Engineers Comments Regarding Surface Water Drainage

Application Reference:	BR/53/26/PL	Reviewer Reference:	12/05/2026
Planning Officer:	Amber Willard	Date of Review:	ADC/EXT5/AF
Site Name:	57 Queensway Bognor Regis PO21 1QN		
Application Description:	Demolition of existing brick-built garages, removal of canopy structure, remediation of contaminated land and construction of 18 No flats over 3 storeys with pitched roofs (resubmission following BR/67/25/PL). This application is in CIL Zone 4 (Zero Rated) as flats.		
Assessment Number:	1

Roof Plan

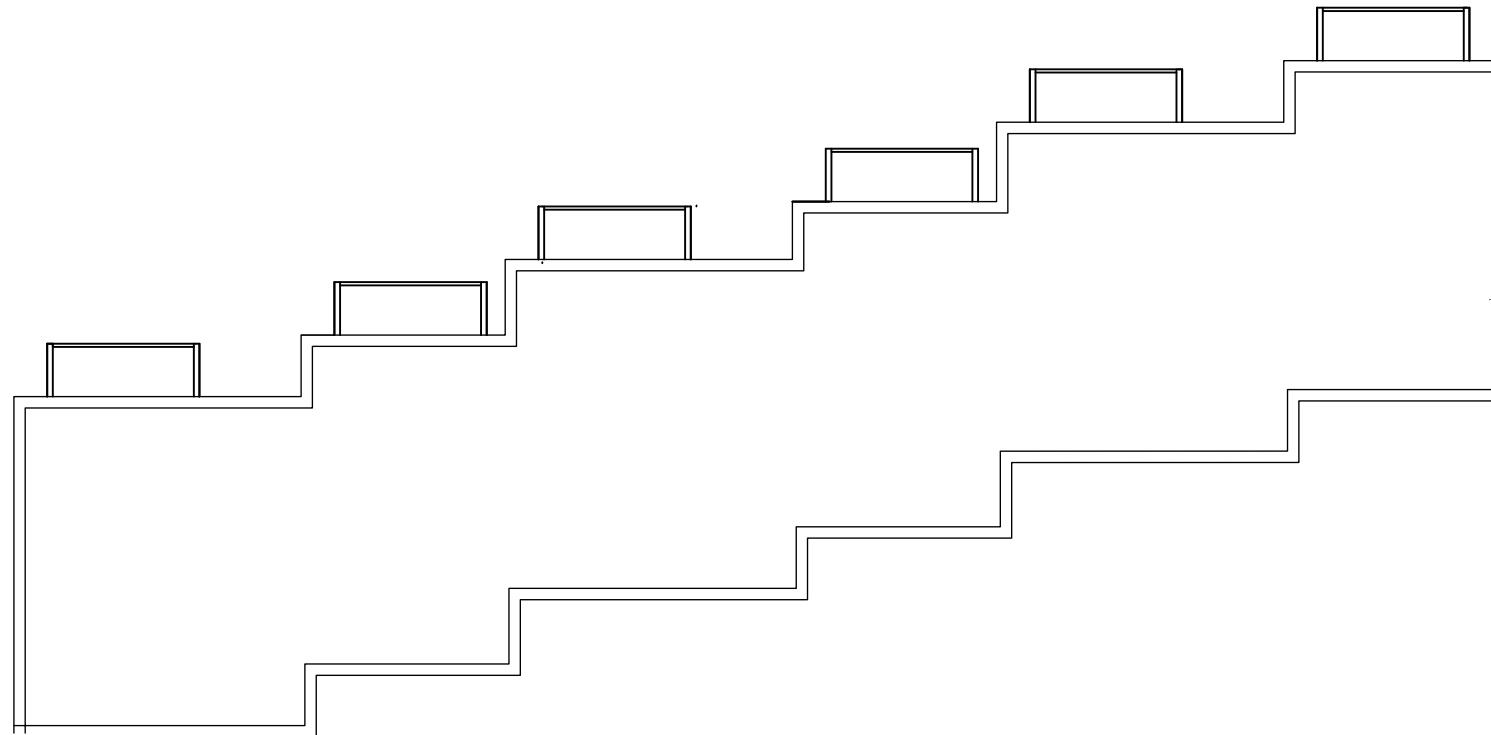
- 2.1. The parking area is permeable which allows for the self-drained area.
- 2.2. NSfS confirms that water butt do not provide interception. There are planters provided for the residential roof drainage but no calculation to confirm the development meets the requirements of the NSfS. Calculations should be provided in the Drainage Statement.

- 2.3. Evidence has not been provided to justify the lack of interception drainage provided as part of the sustainable drainage design. Interception drainage is not currently in accordance with the requirements of the NSfS. Therefore, we **object** to the application.

- 2.5. Where infiltration is not viable, there is a risk that interception drainage may only be delivered by evapotranspiration. No SuDS features which allow evapotranspiration are proposed. No departure from the national standards from SuDS has been requested. It is unclear where interception features may be included within the proposed scale and layout.

[UW Response: Drainage Strategy DS\[U0560\]-V3 has been updated, with green roofs proposed on the entire development flat roof \(refer to typical details\), including the bin store, to provide the necessary interception for the roof area.](#)
